**Planning consultation: Application by One Earth Solar Farm Limited for One Earth Solar Farm. The Examining Authority's request for information and follow up to Examiner's Question 3.**

**Location: One Earth Solar Farm**

## Annex A: Natural England's Response to the Examining Authority's Third Written Questions

# Annex B: Natural England's Updated Comments on Cumulative Assessment of Soils from D4

Client:
One Earth Solar Farm Ltd

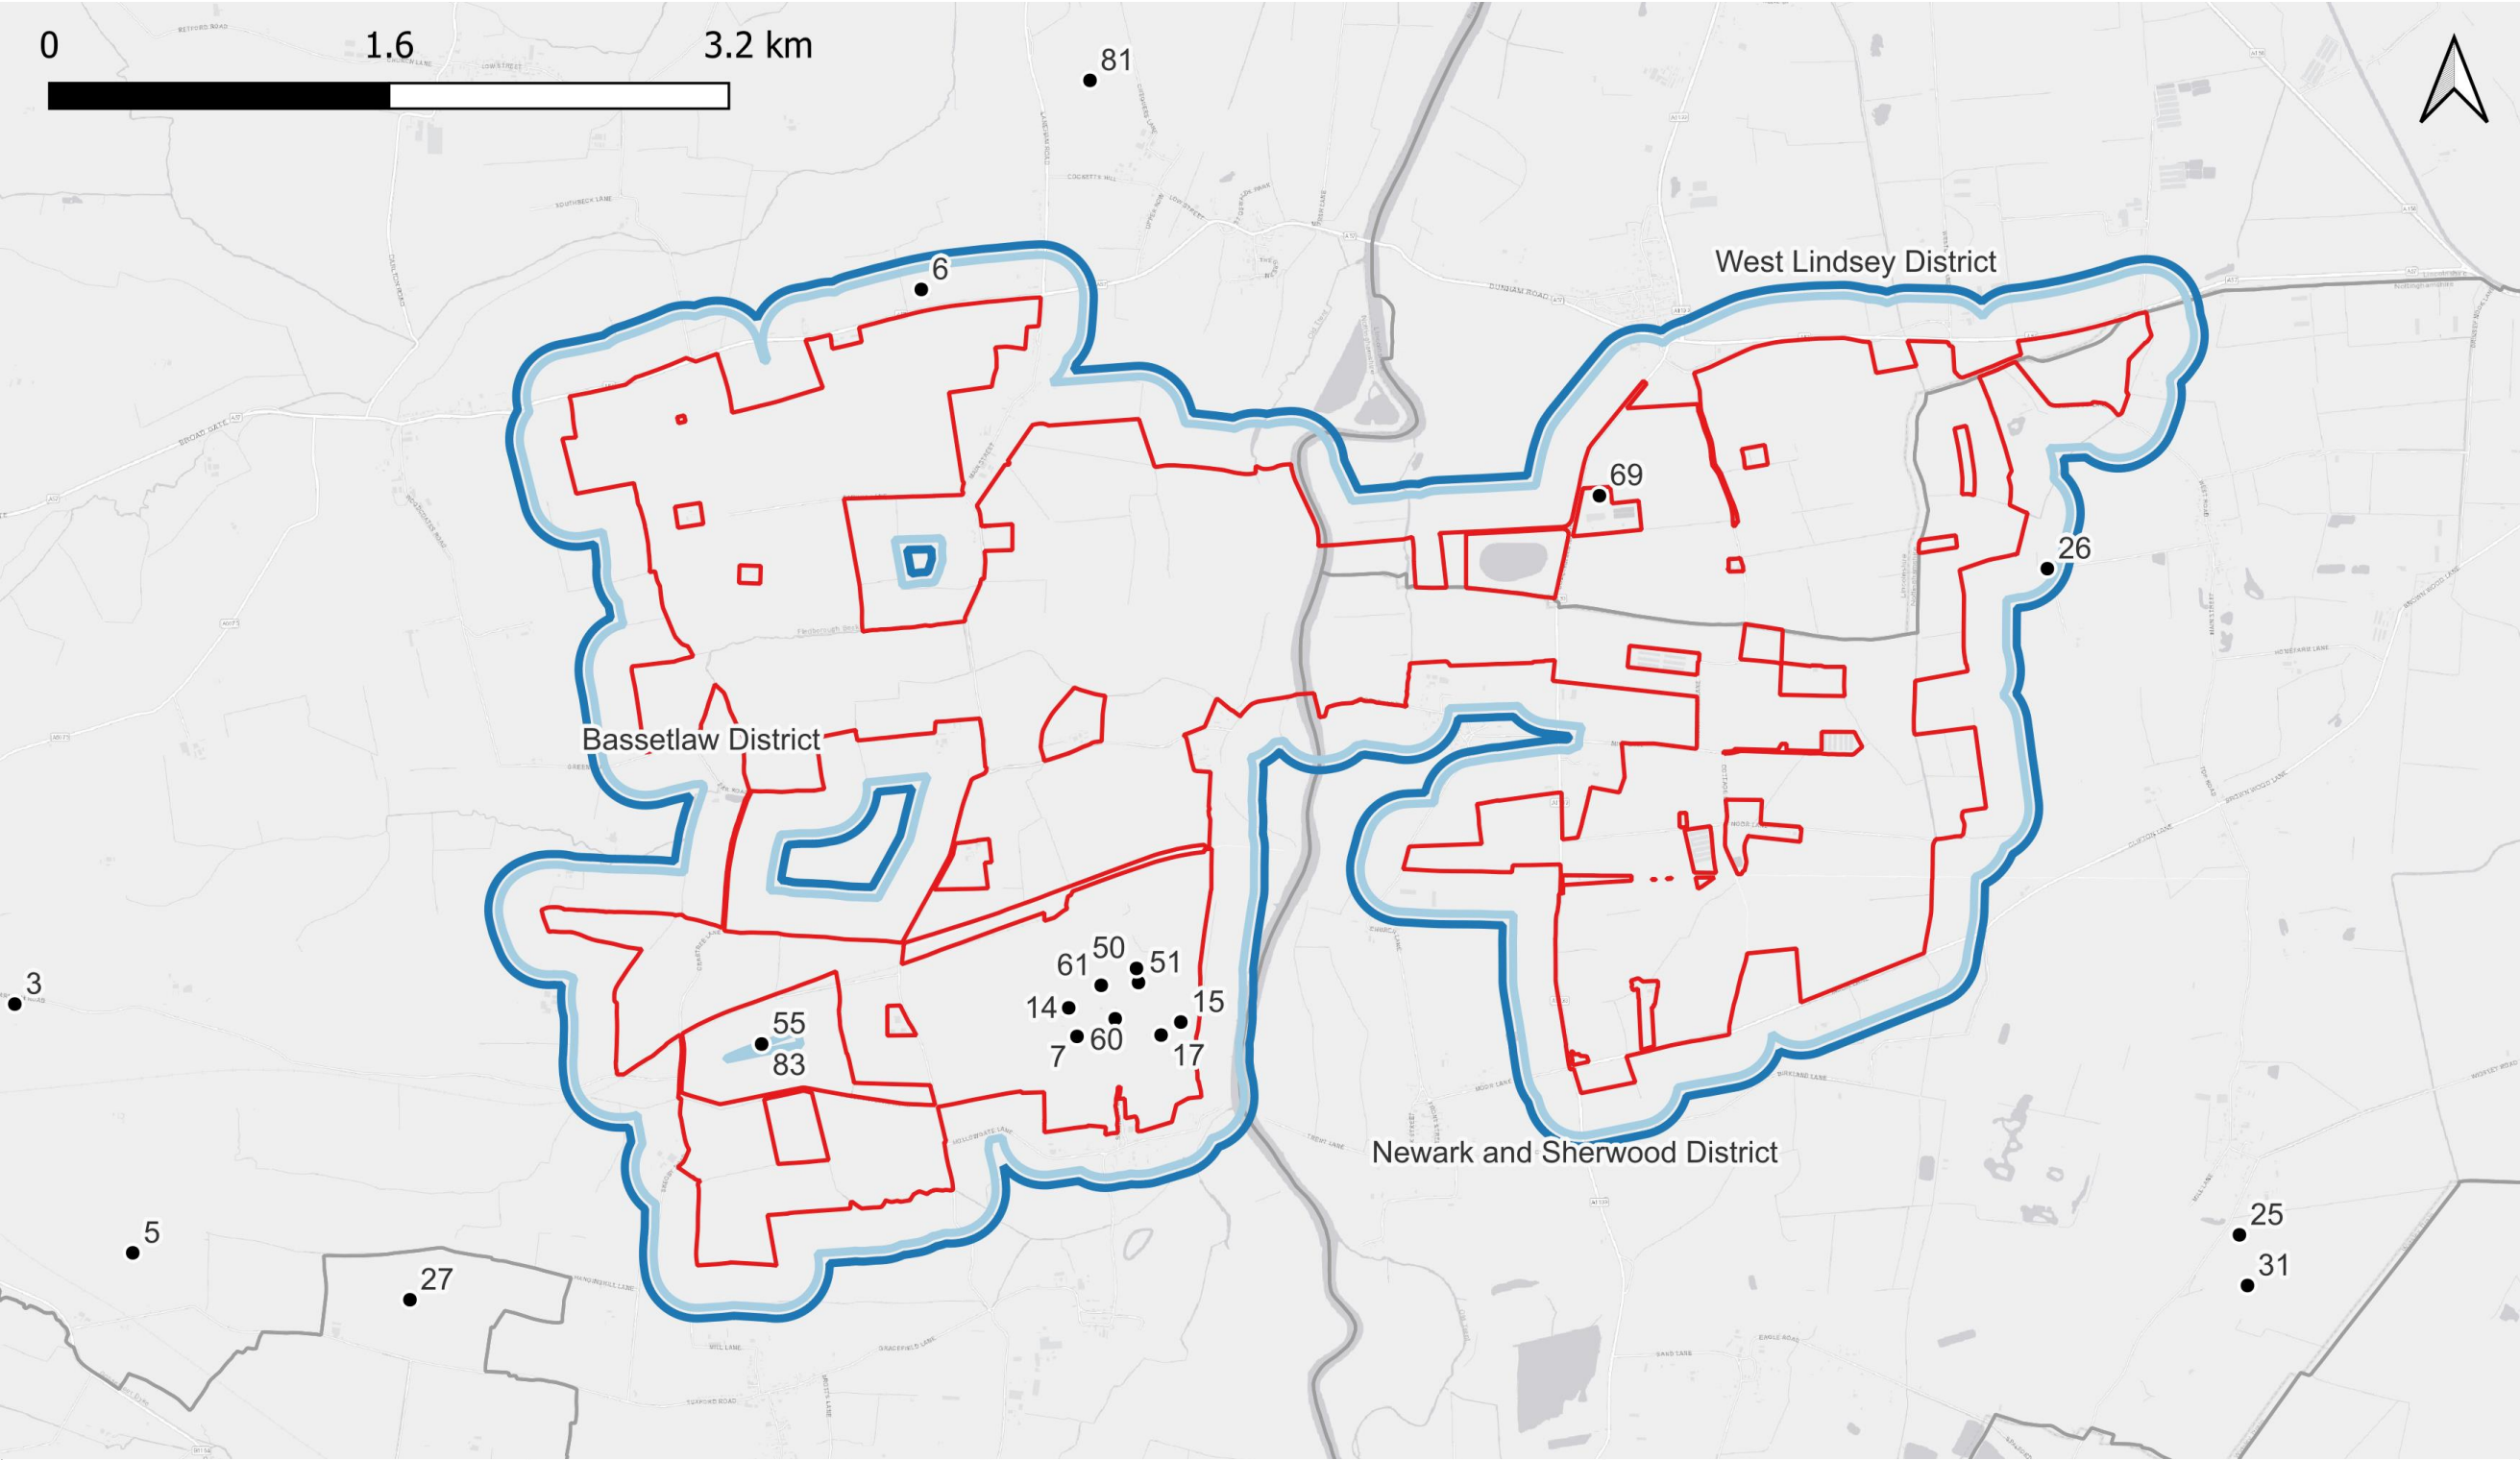
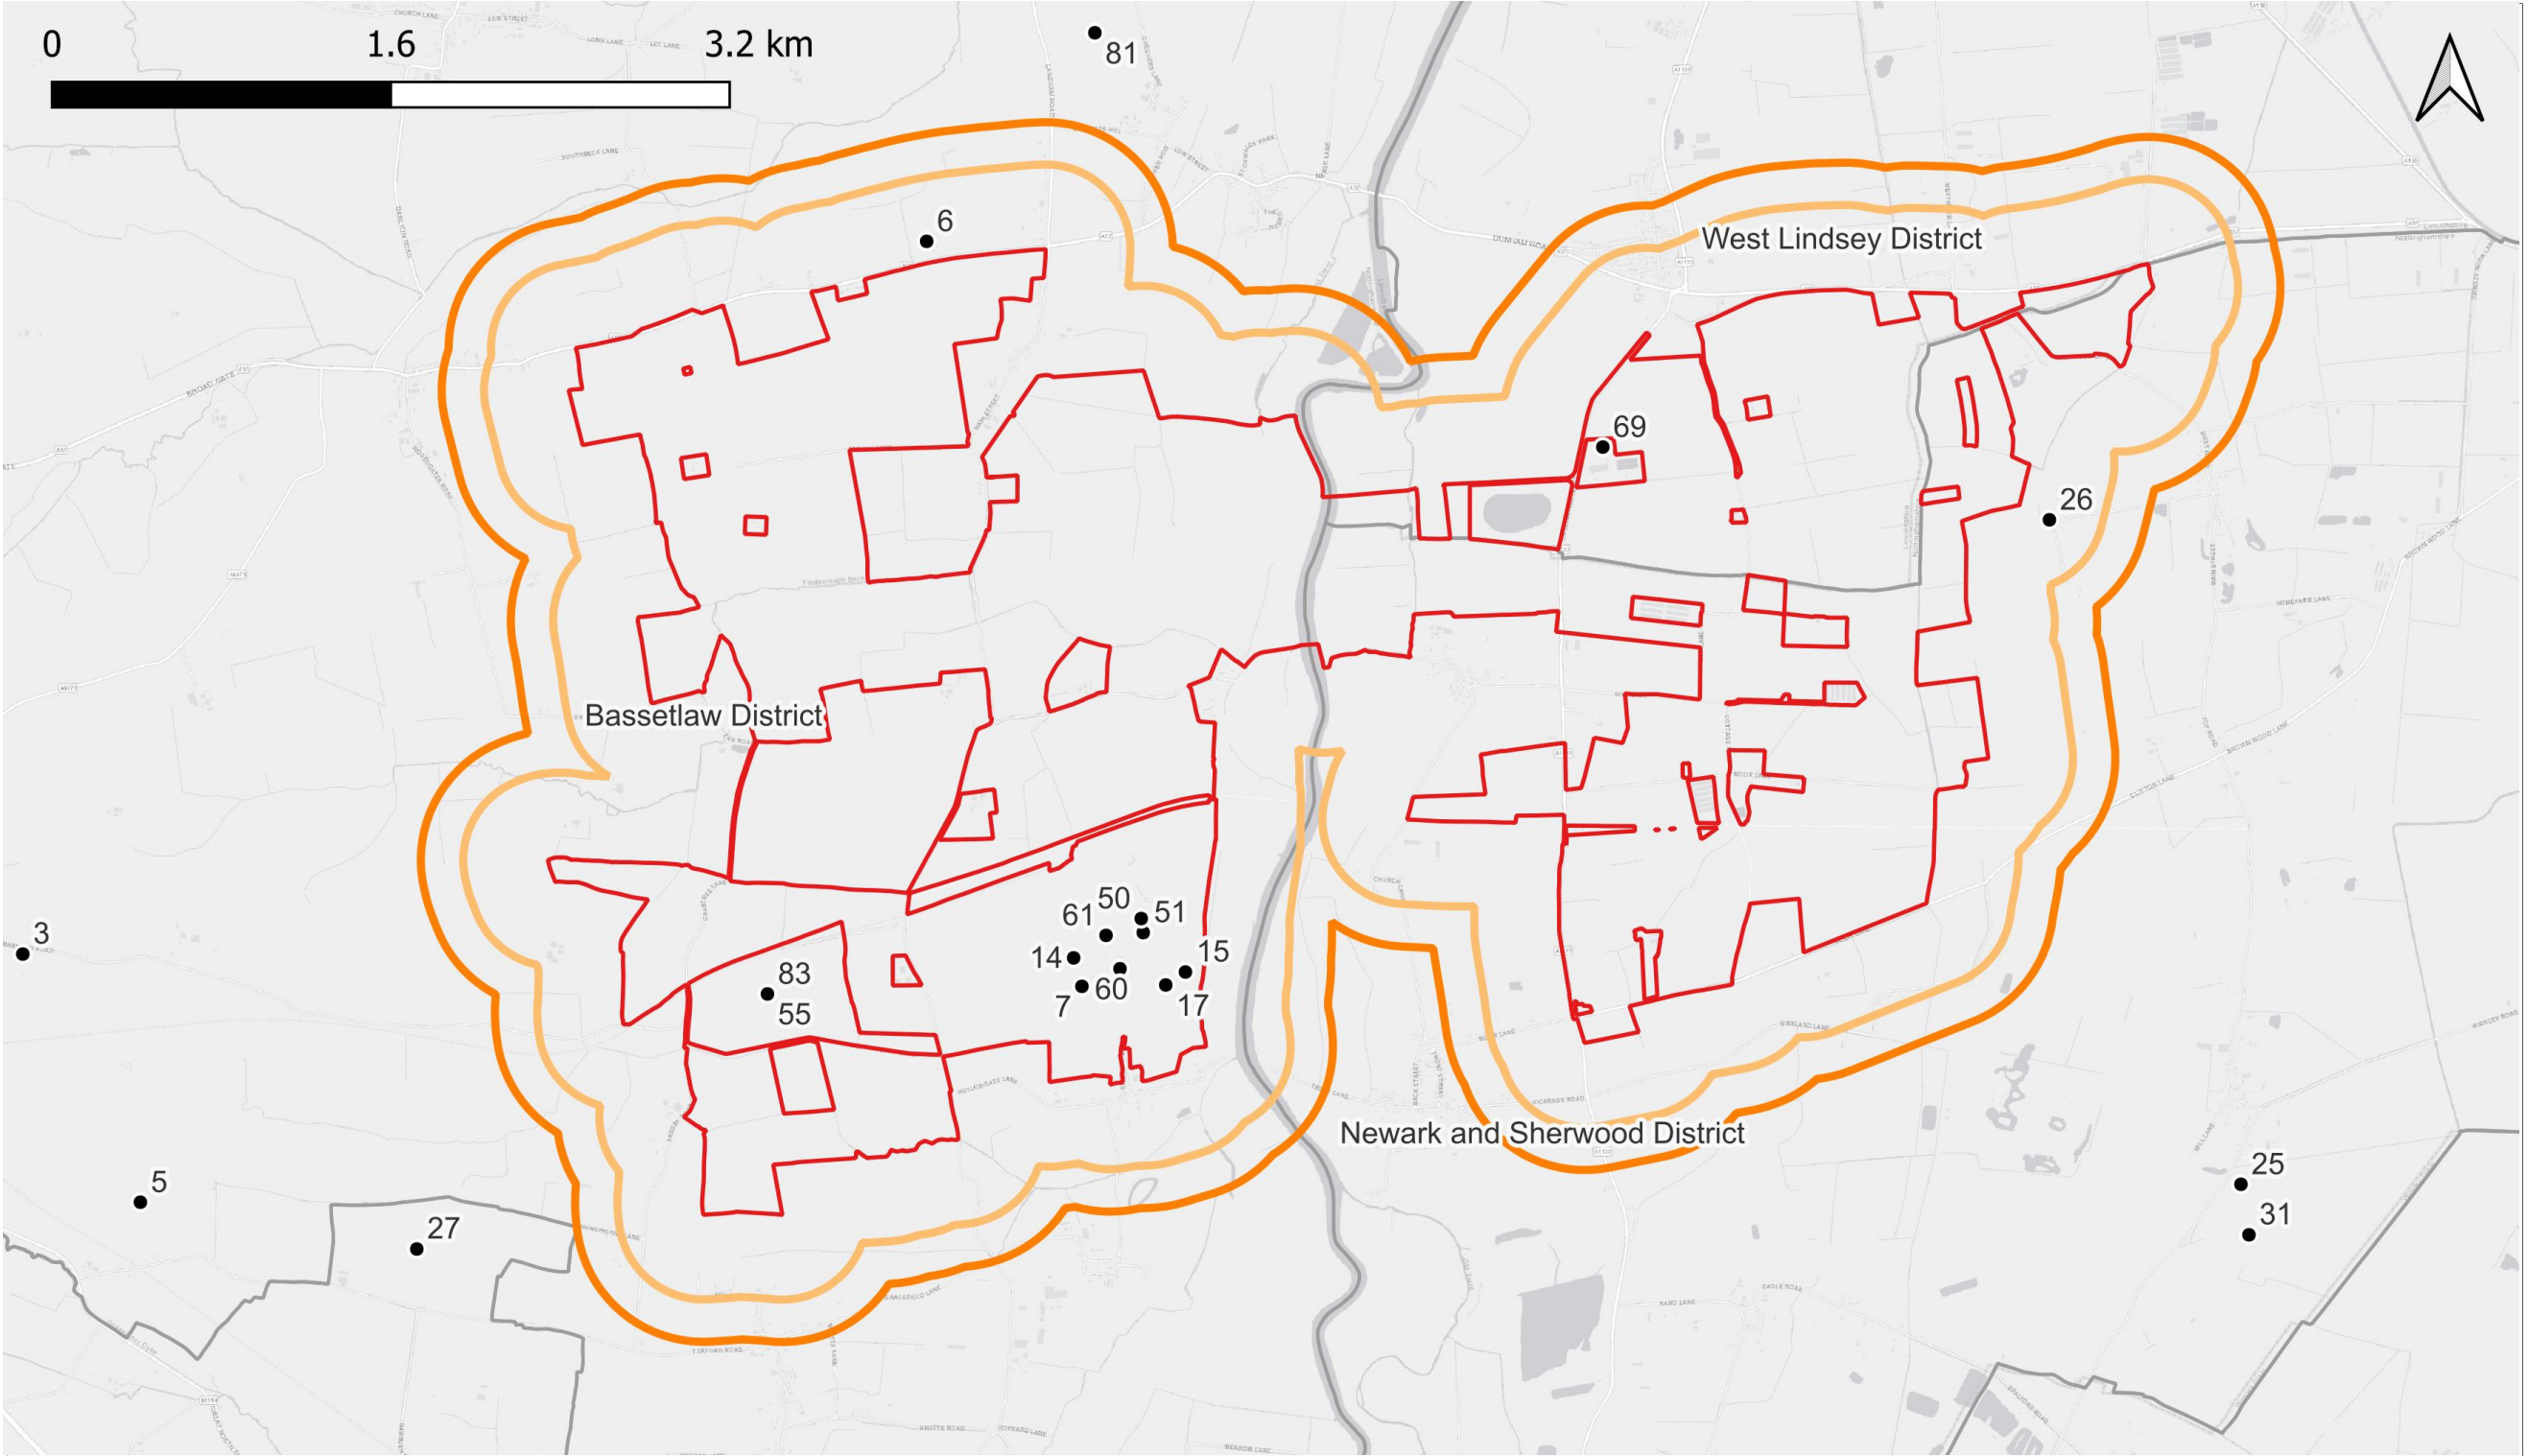
**18.3.19** Natural England are broadly satisfied with the regional Zol and the information provided within ES Volume 3, Figures 18.1 to 18.8 [EN010159/APP/6.20] for a regional cumulative assessment, however we refer the applicant back to the comment above (table 18.2)

D6 Update: No further comment.  
D7 Update: No further comment.
